# CITY OF PORTLAND, MAINE

April 28, 2015

Project Name:	May Street Townhouses	Project ID:	2014-149
Address:	7-9 May Street	CBL:	057 C023 001
Applicant:	May Street 7-9, LLC		
Planner:	Shukria Wiar

## MEMORANDUM

CONSTRUCTION MANAGEMENT PLAN KEY

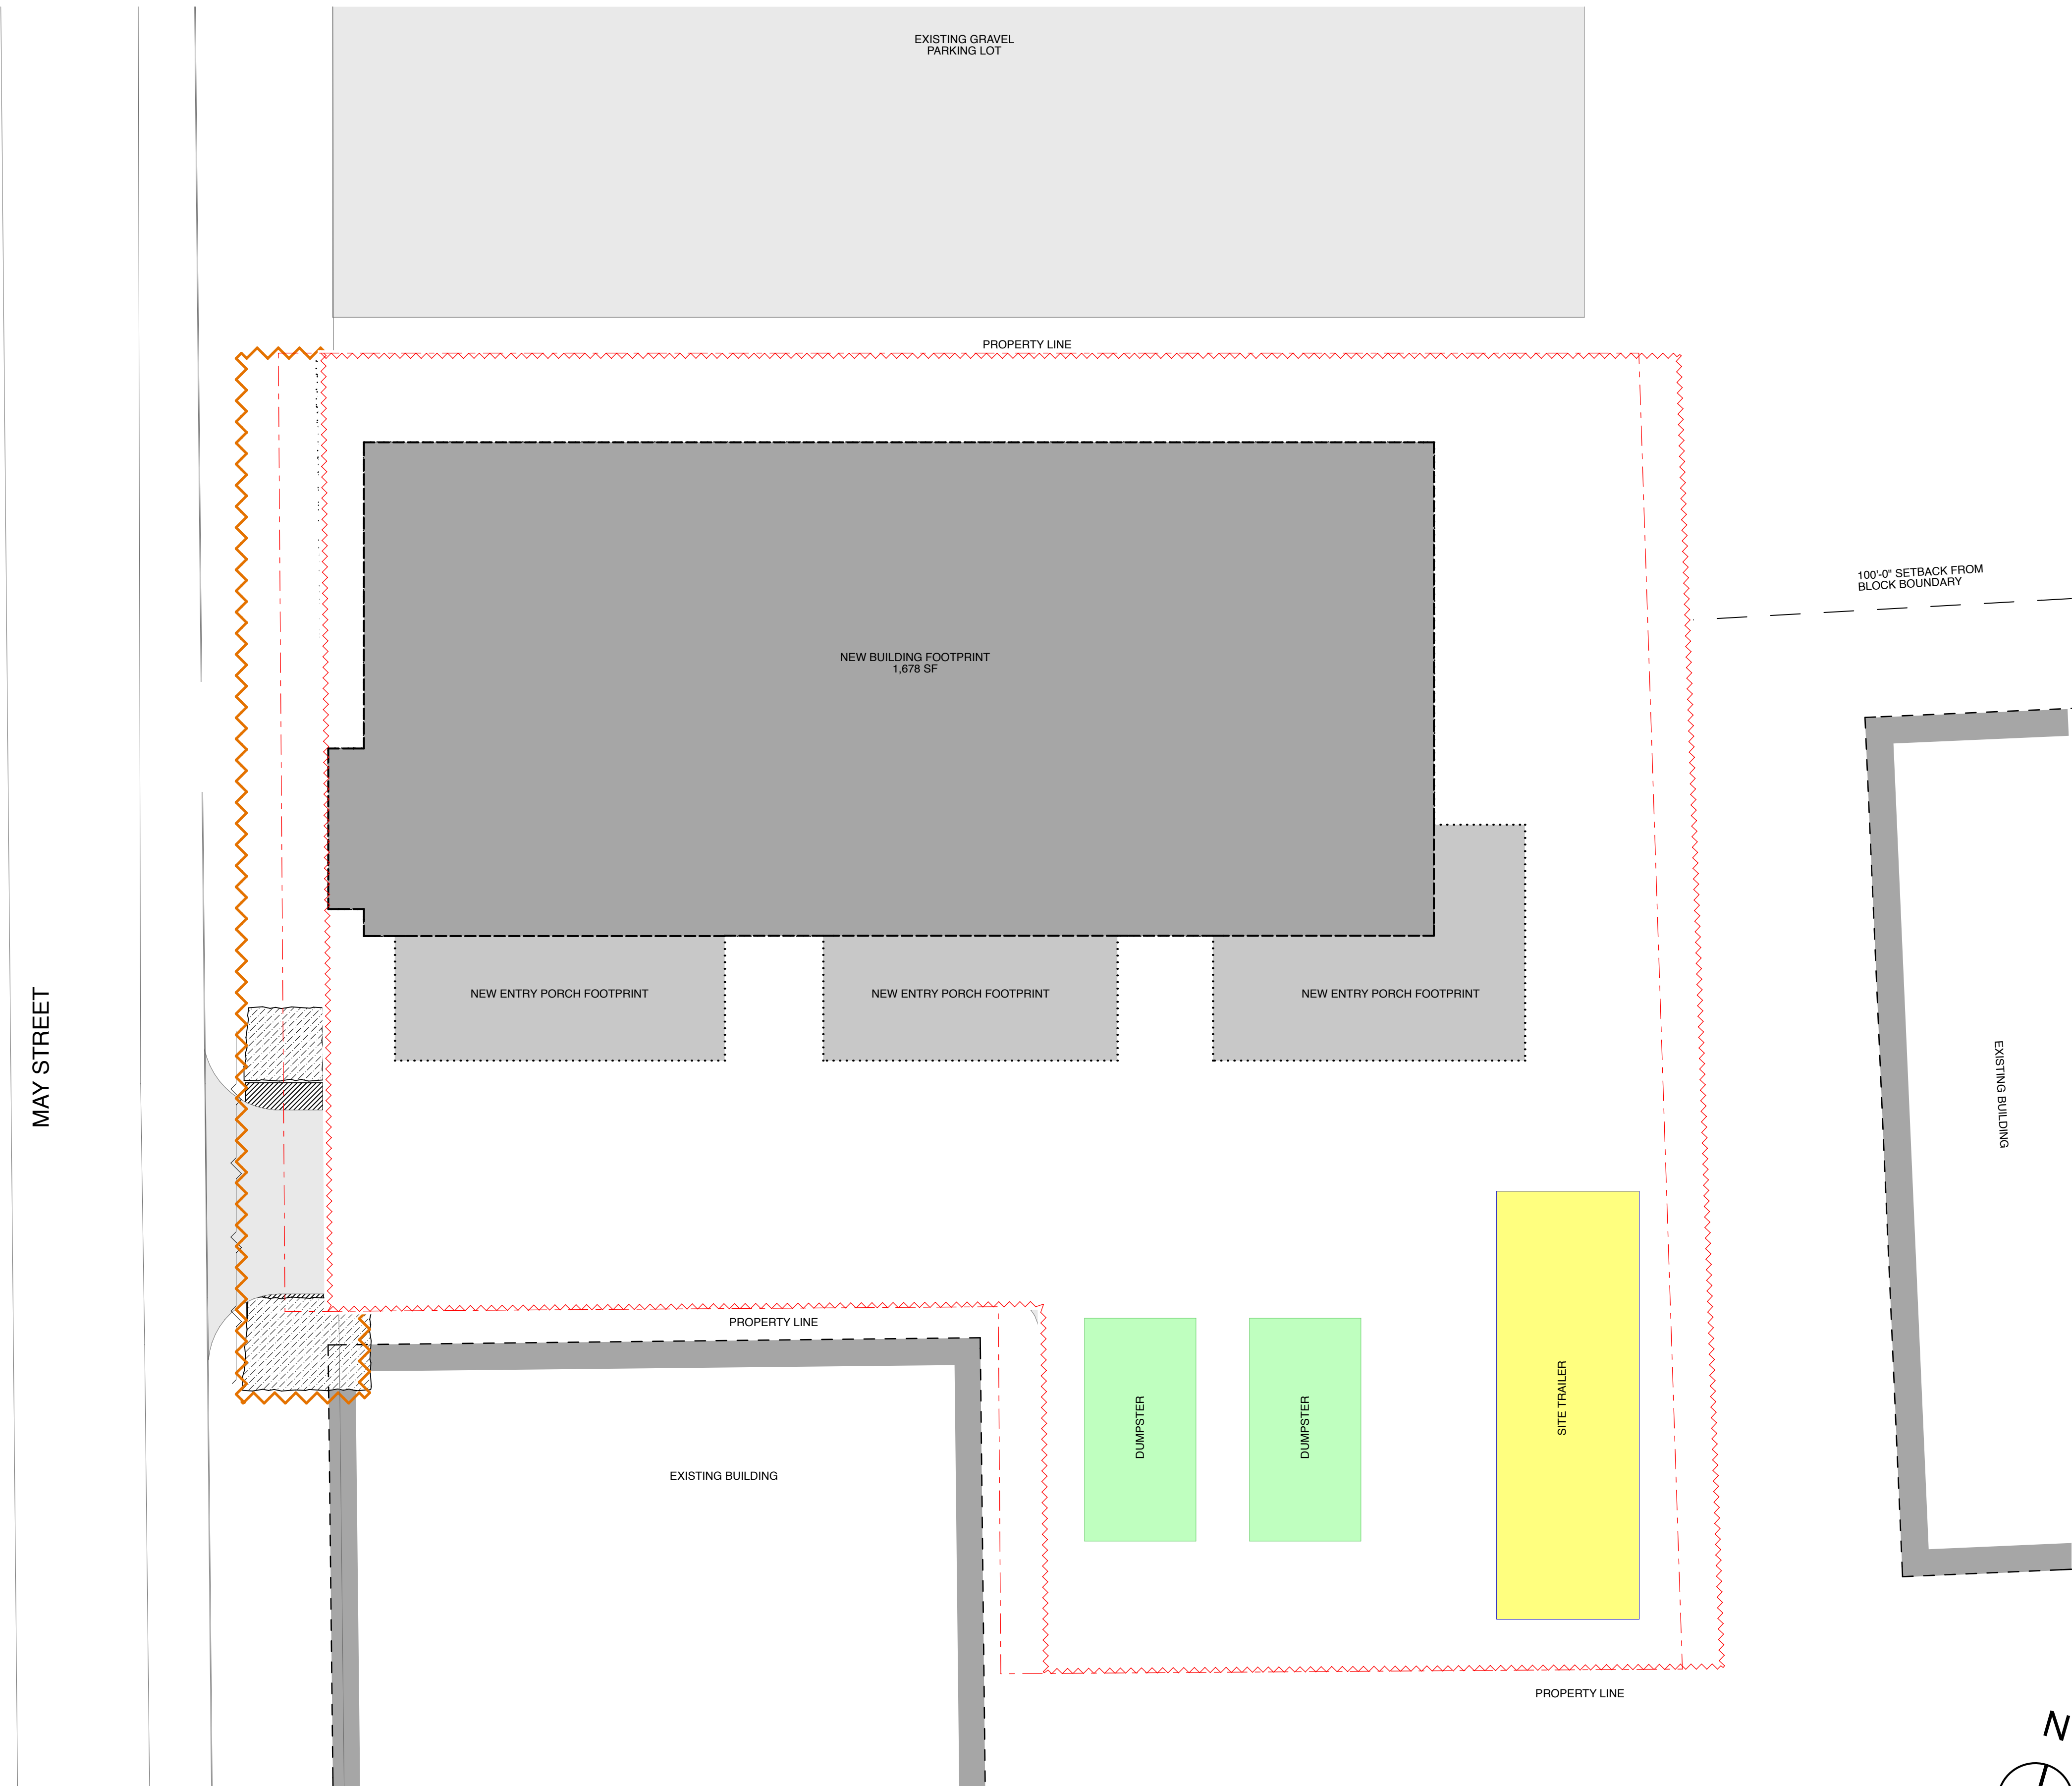
3. That the construction management plan shall be revised to show the sidewalk closure detail plan during construction, which shall be reviewed and approved by the Planning Authority prior to the issuance of a building permit; and

A construction management plan has been submitted by the applicant for review. All the construction is proposed within the limits of the property lines. Tom Errico has reviewed the plan and notes that "the applicant will be required to provide a sidewalk closure detail plan during construction. Approval of the details will be required prior to construction".

*The construction management plan shall be revised to show the sidewalk closure detail plan during construction, which shall be reviewed and approved by the Planning Authority prior to the issuance of a building permit.*

Drainage & Utility Plan

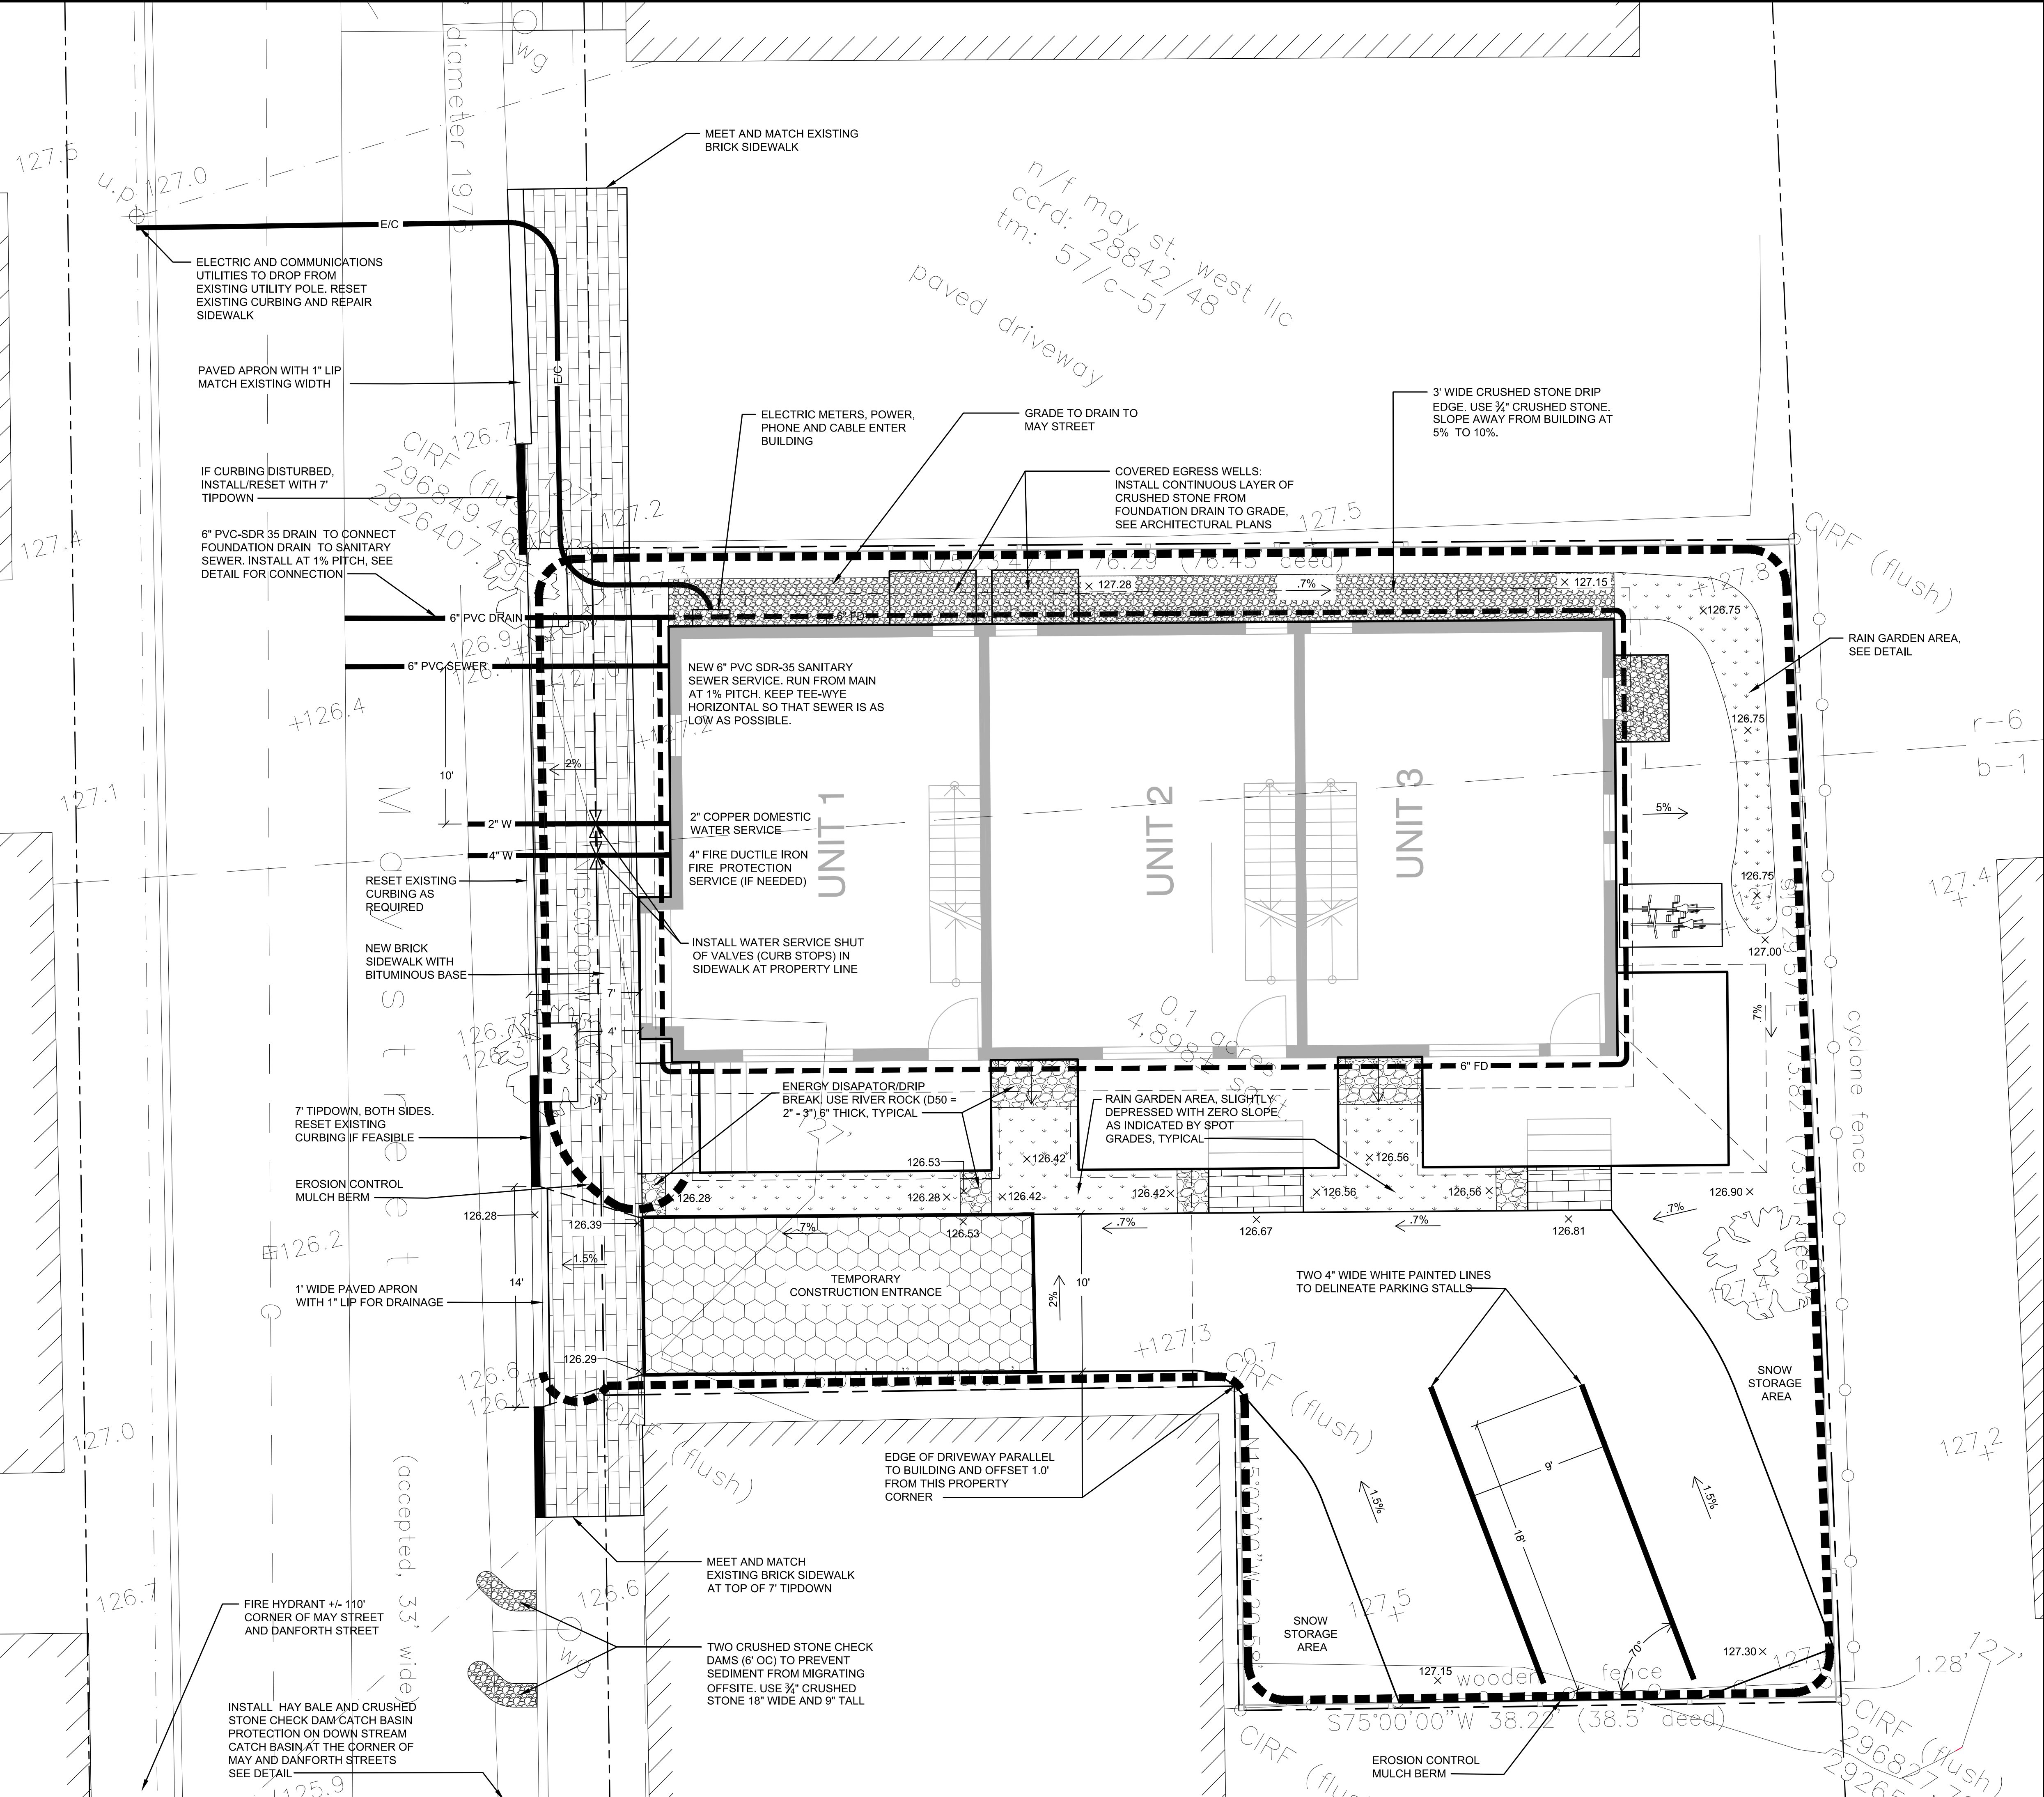
7) The Applicant has noted that basic grading will be required to divert stormwater to the proposed rain garden; however, it does not appear that any proposed grading is shown at this time. Final plans should include proposed grading and drainage collection/conveyance systems (pipes, structures, etc).
